Rosefield Solar Farm (EN010158)

**Rule 17 Examining Authority's Request for Information –
Buckinghamshire Council Response**

Buckinghamshire Council

August 2026

TITLE:
FIGURE 3.8.2
INDICATIVE LOCATION OF PRIMARY AND
SECONDARY CONSTRUCTION COMPOUNDS

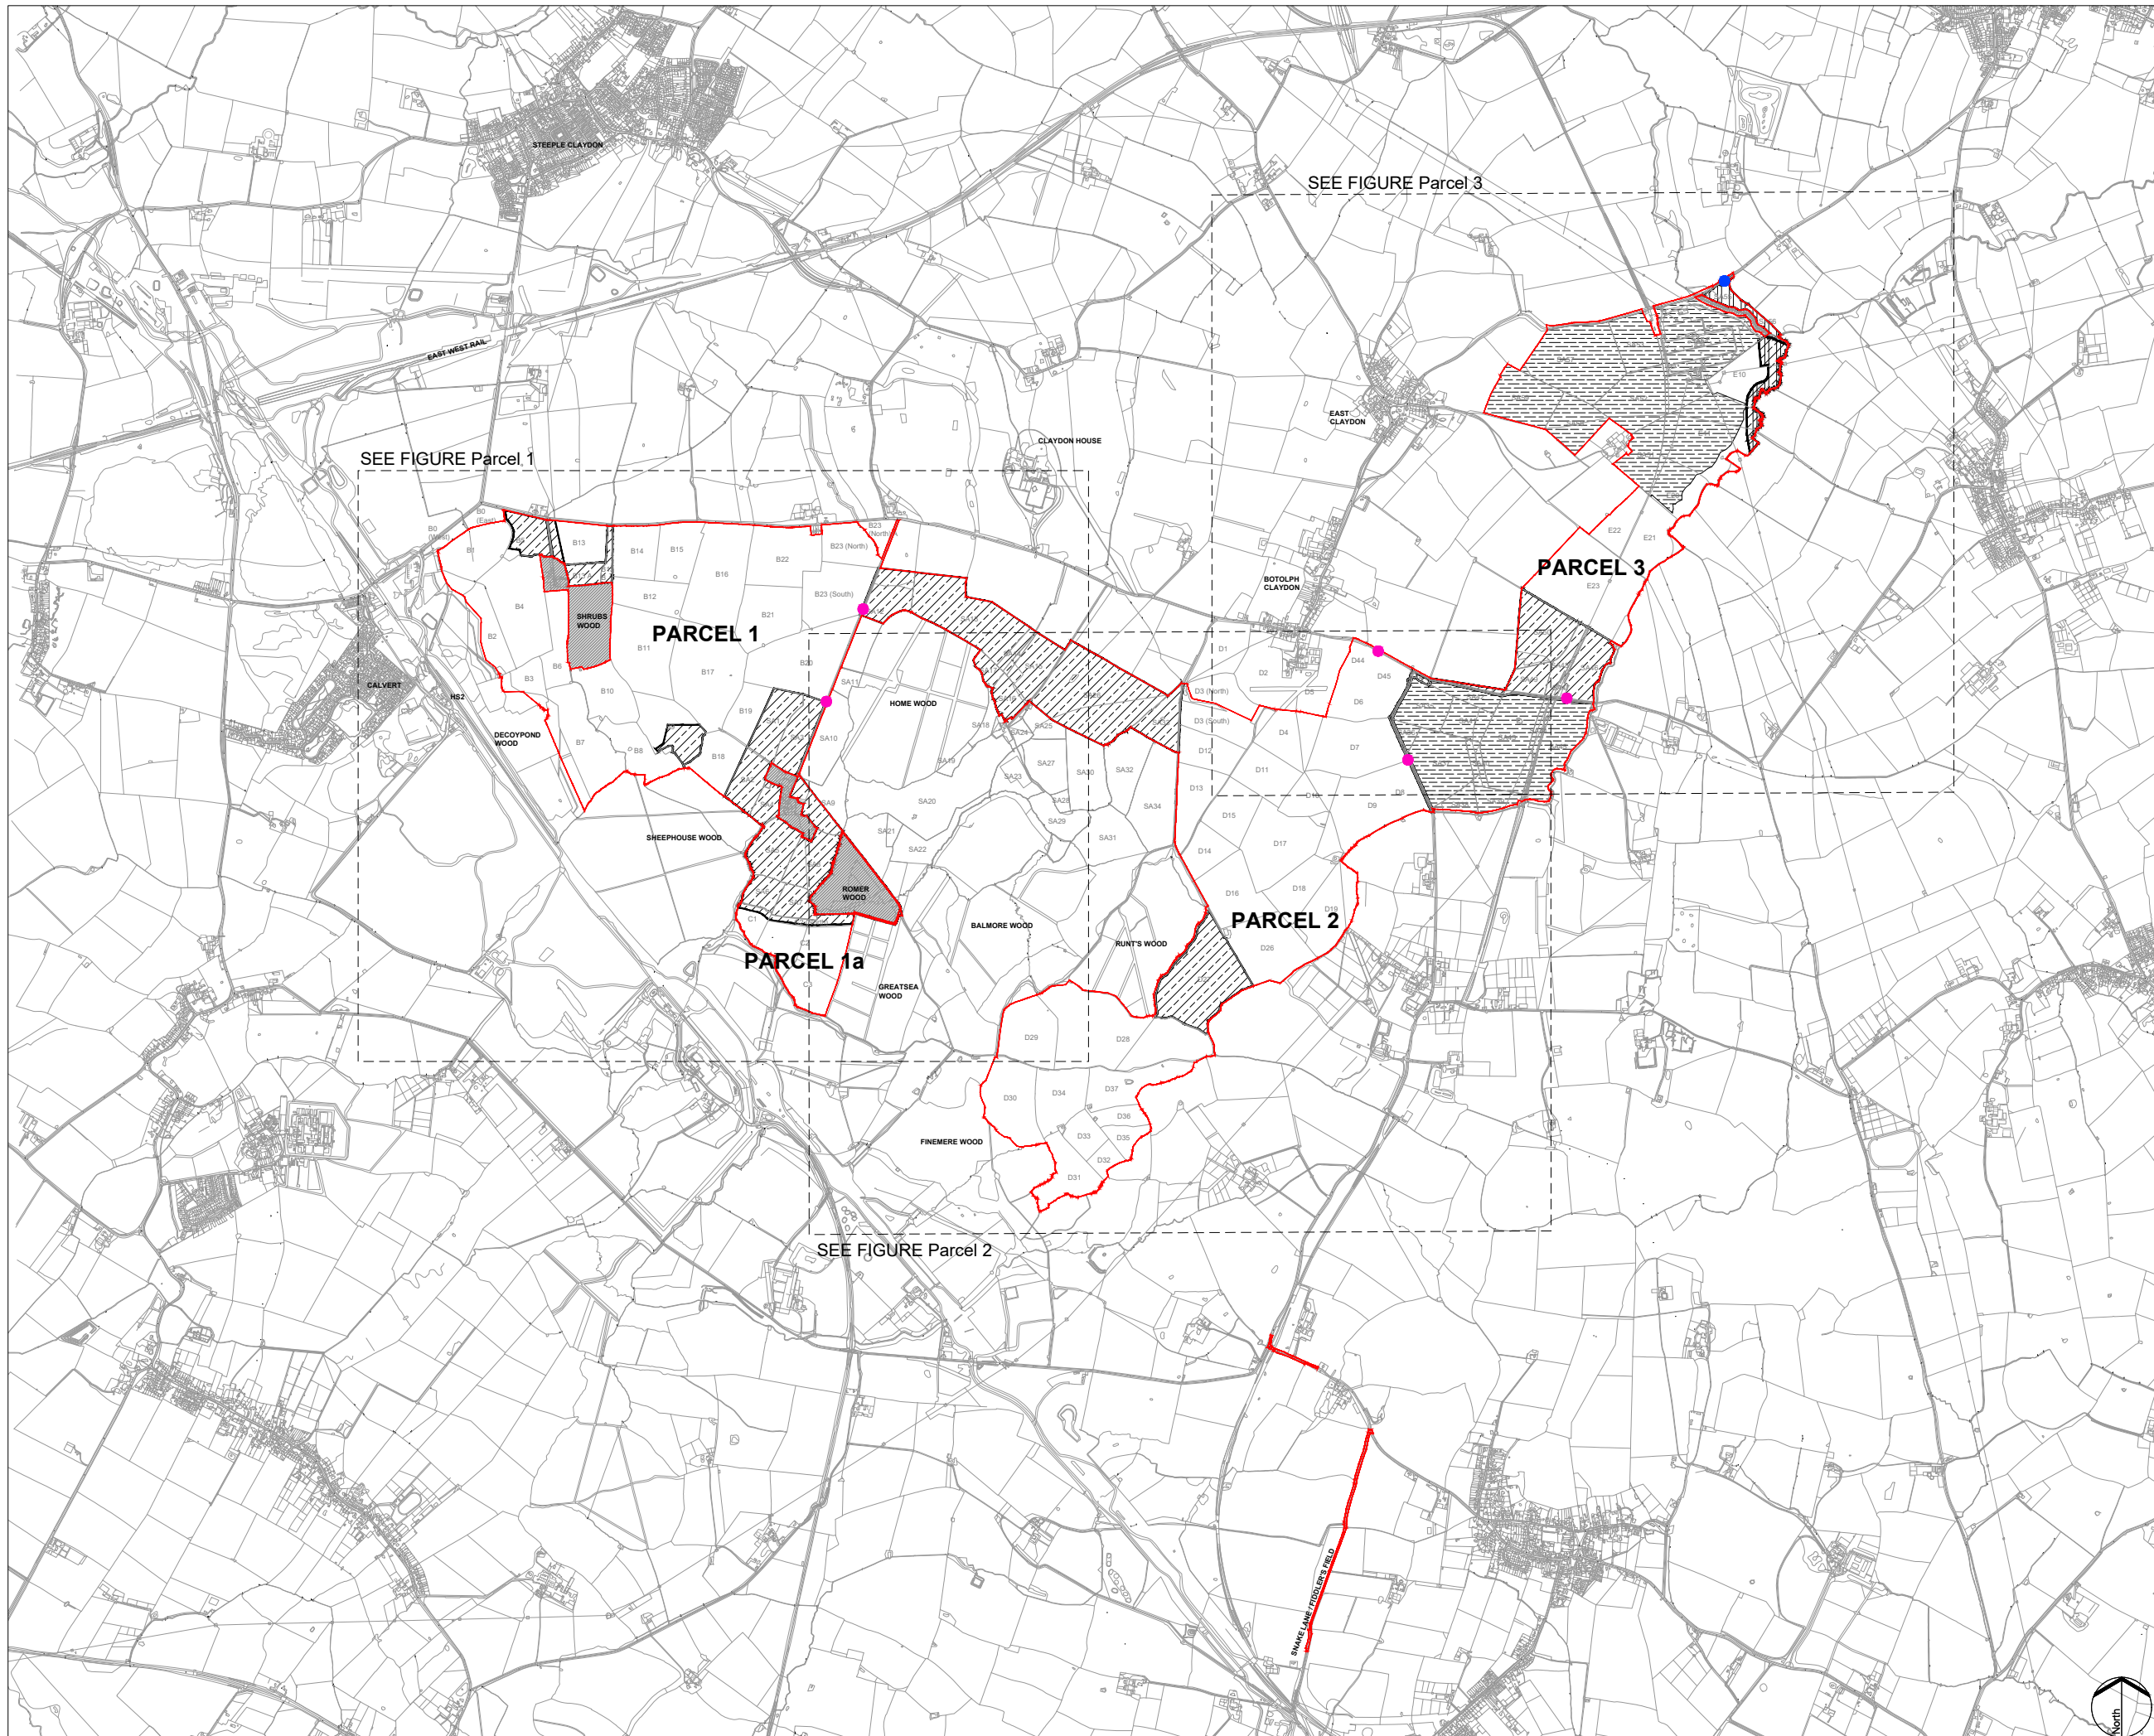
24. The Council supports the recommendation from Natural England to locate the construction compound within parcel 1 away from boundary features where possible and would welcome wording to this effect being provided.
